**Re AUSTRALIAN MUSEUM – ALTERATIONS & ADDITIONS  
SSD 9452  
REVISED DESIGN STATEMENT**

In response to the feedback received from the Government Architect on the 18<sup>th</sup> December 2018 regarding SSD 9452 for the Australian Museum – Alterations & Additions the design team has completed a review of the feedback with the Museum to address the key points raised. The key changes following the SSD submission on the 11<sup>th</sup> August 2018 are detailed below. Please read these in conjunction with the updated drawings, reports and submissions table.

FLOOR PLAN - BASEMENT LEVEL - PROPOSED  
AM ADDITIONS & ALTERATIONS

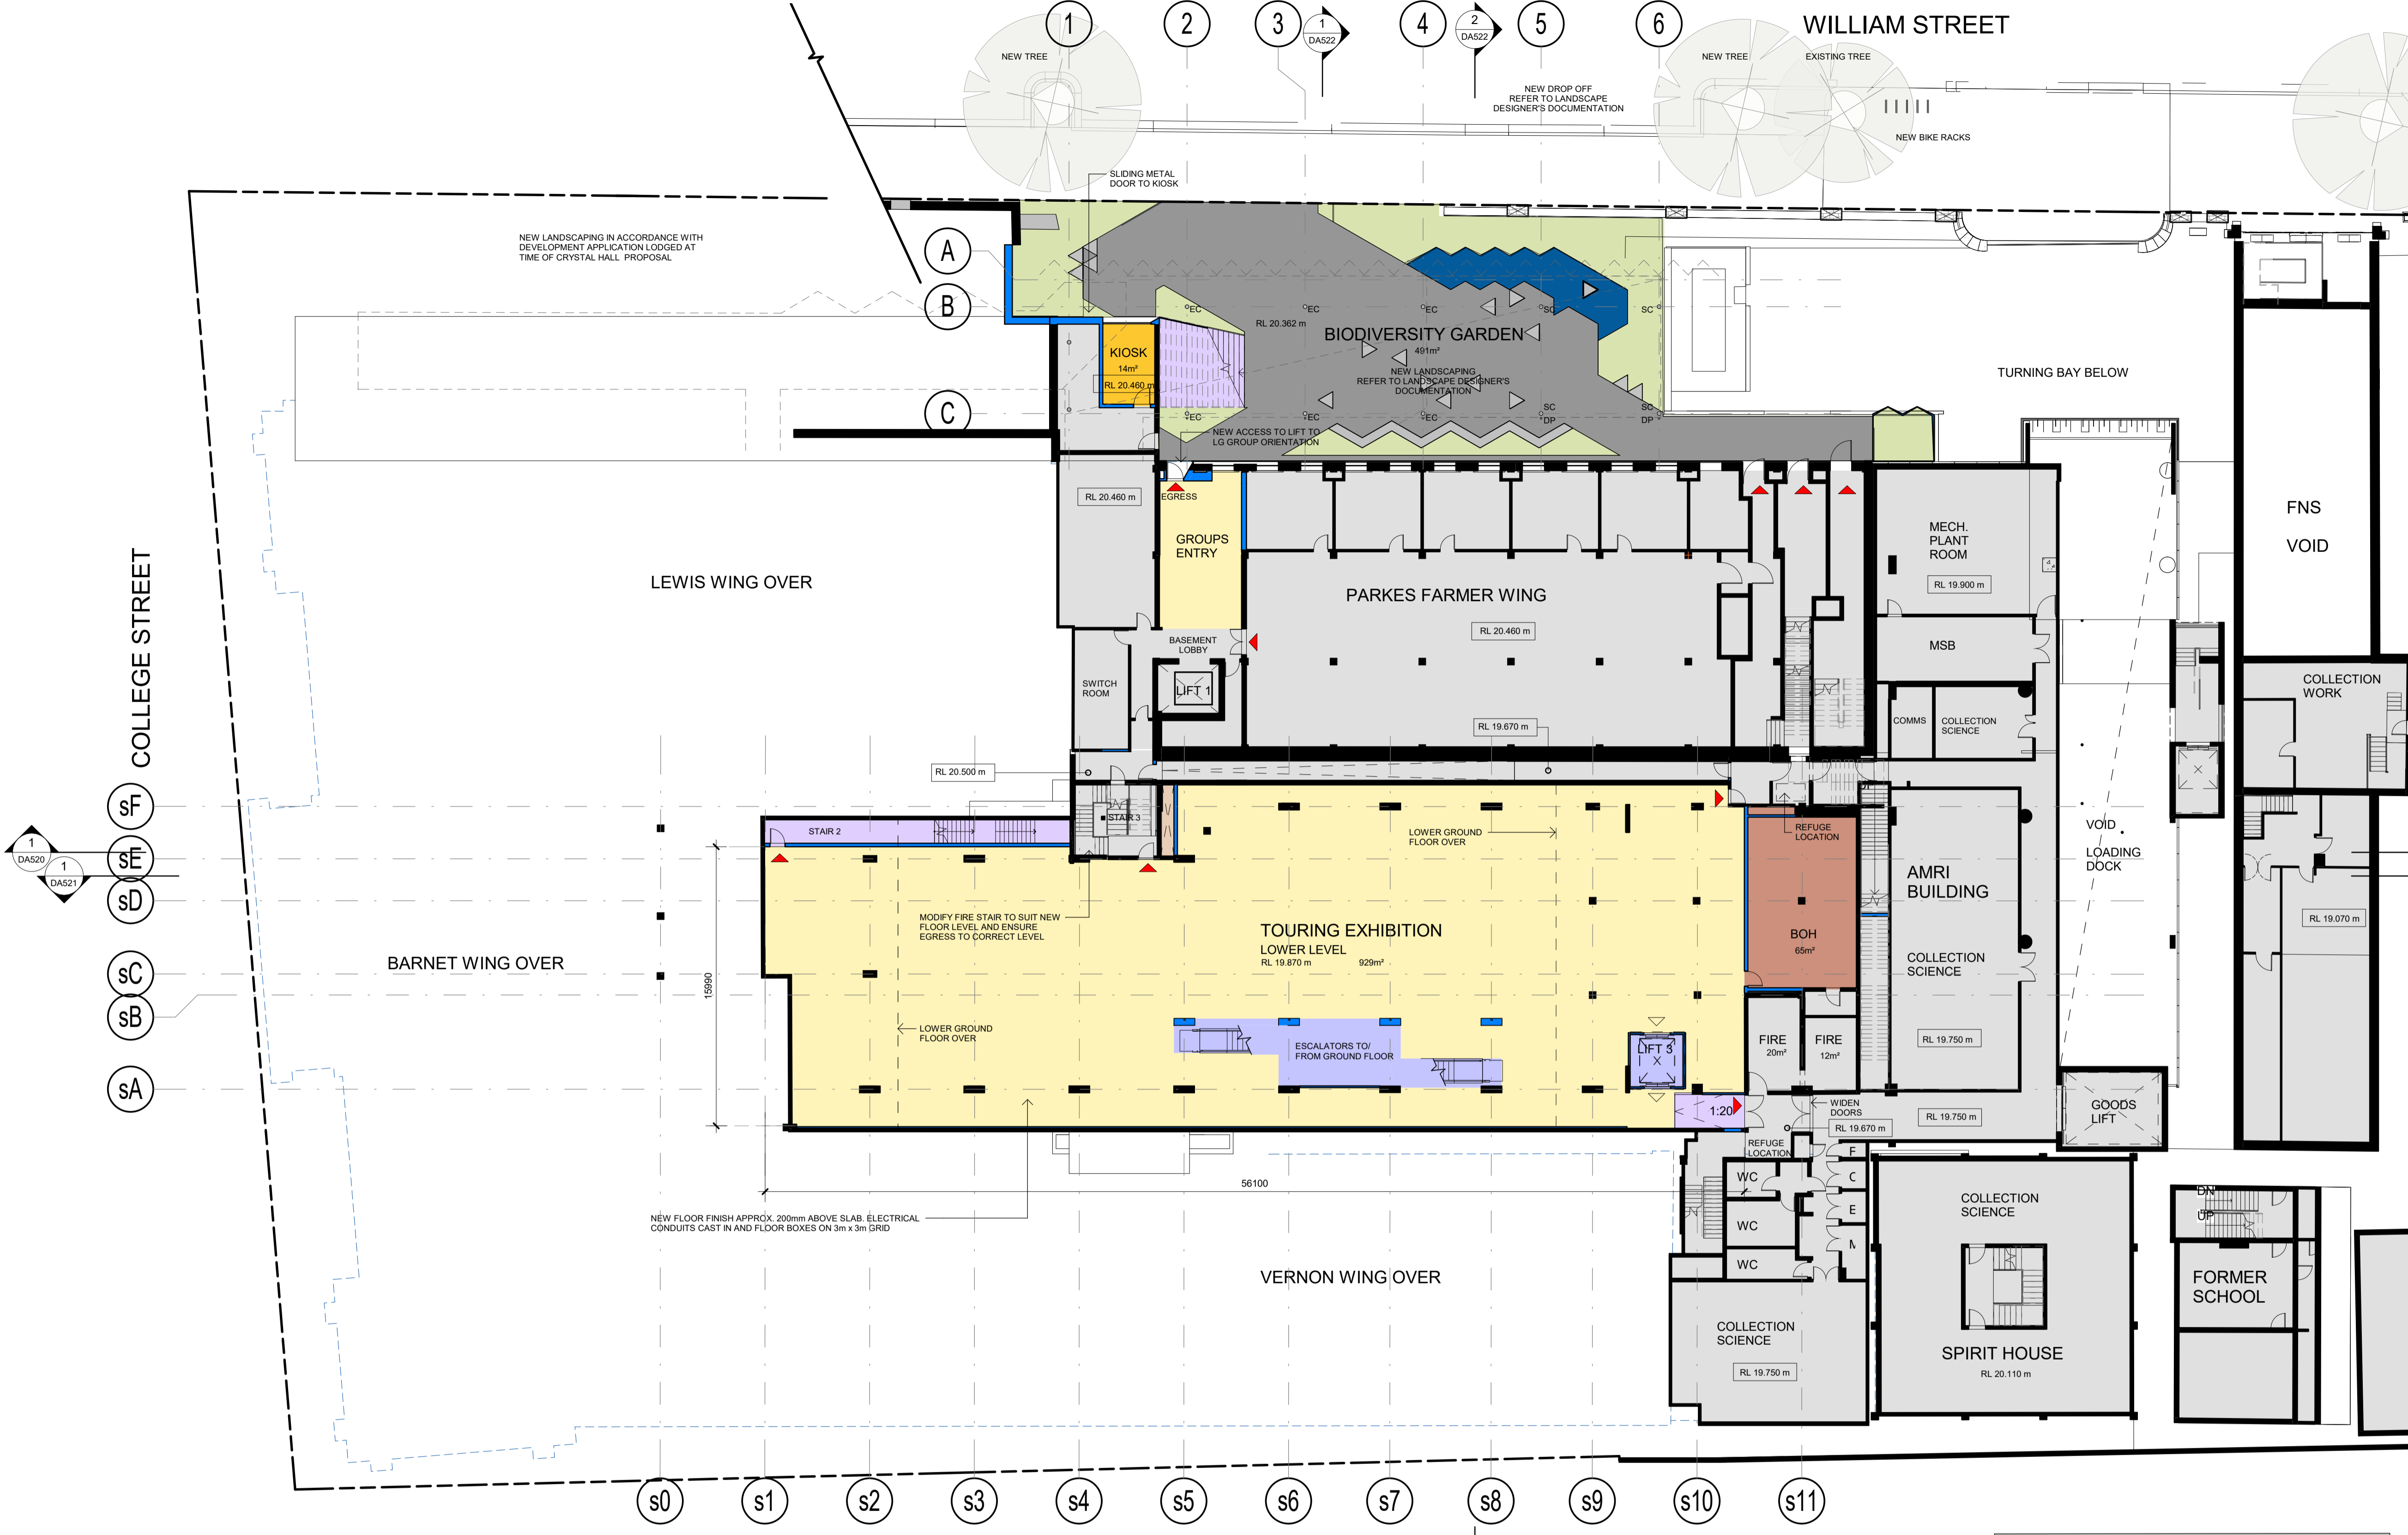
- The touring exhibition space on the basement level is a permanent gallery, retained into the future.
- The amended fire stair is relocated to the glazed link (between the Parkes Farmer and Lewis wings) so that it can be retained into the future. It significantly improves museum circulation, provides a strong engagement with St Mary’s Cathedral and Cook and Phillip Park, and improves buildability.
- The amended escalator to the basement level touring exhibition space accommodates the raised heart floor, and can be retained into the future. It

- The amended amenities are relocated to the lower ground level of the Lewis wing, which is anticipated to become the future entry level. These amenities can be retained into the future. This is ample space here to include an appropriately scaled cloakroom, significantly improving the functionality of the visitor services.
- A wider opening to the northern façade of the Parkes Farmer wing in combination with the relocated fire stair improves circulation and consolidates the public entry and exit to the museum. This amended circulation locates the museum shop on the exit path, improving visitor flow and negating the need to extend Crystal Hall. The wider opening can be retained into the future.

- The amended location of the groups amenities works much better with the existing services to avoid disturbance to palaeontology located in the basement below. It establishes a designated amenities for groups, separate to the public amenities.

FLOOR PLAN - LOWER GROUND - PROPOSED  
AM ADDITIONS & ALTERATIONS

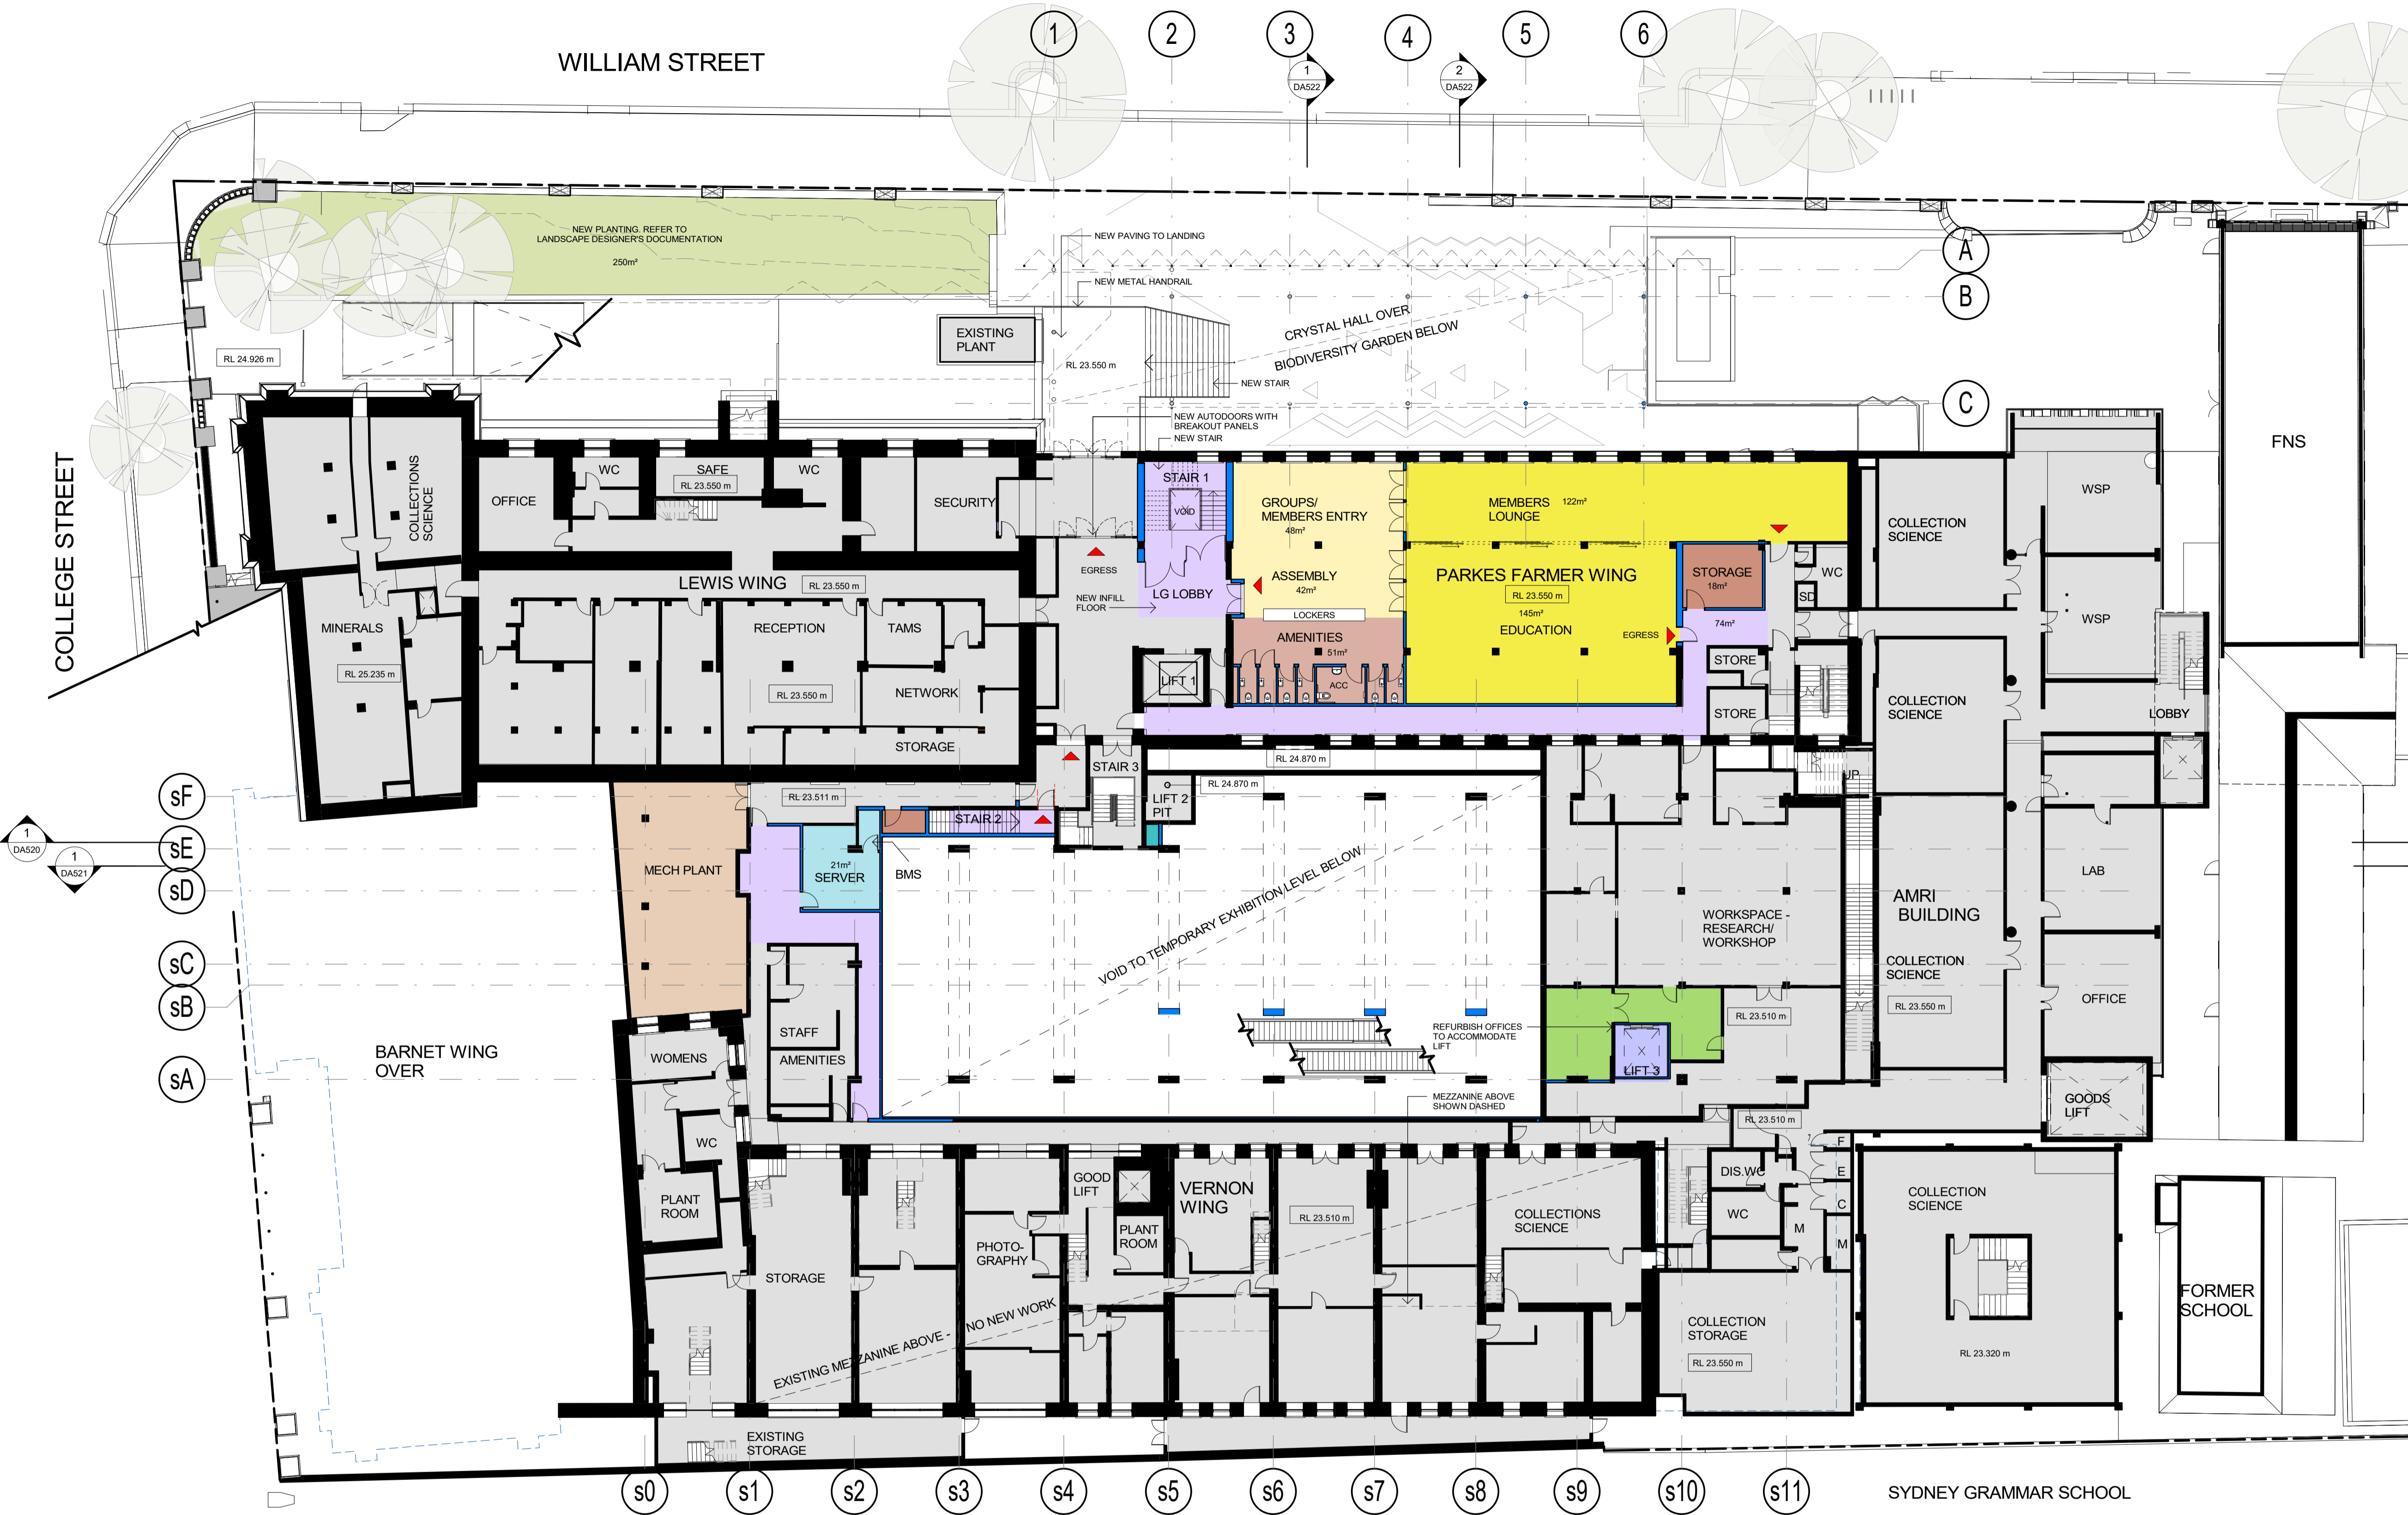
The ‘heart’ (Still Addition, ground level) is the main space of the museum – its grand hall / orientation space. The amended design raises the ‘heart’ floor to match the Vernon / Barnet levels. This effectively enlarges the heart and establishes more legible and equitable access to the historic exhibition spaces around it. The new floor level is consistent with the future vision, which anticipates the extension of the heart east towards Yurong Street.

- Visibility to the new basement groups entry is improved by retaining the William Street stair in its existing location, and relocating the existing coffee cart to the eastern end of the Crystal Hall undercroft. This also creates a generous covered marshalling space for school groups.

- Amended landscaping to the undercroft establishes a more direct connection between the bus drop off and the basement groups entry. The retained William Street stair also has a direct connection to the bus drop off.

- The rationalised entry arrangement allows group marshalling under the Crystal Hall, queuing in the more generous lower ground lobby, and additional queuing at the top of the William Street stair. A reception and security point is located at the lower ground entry.
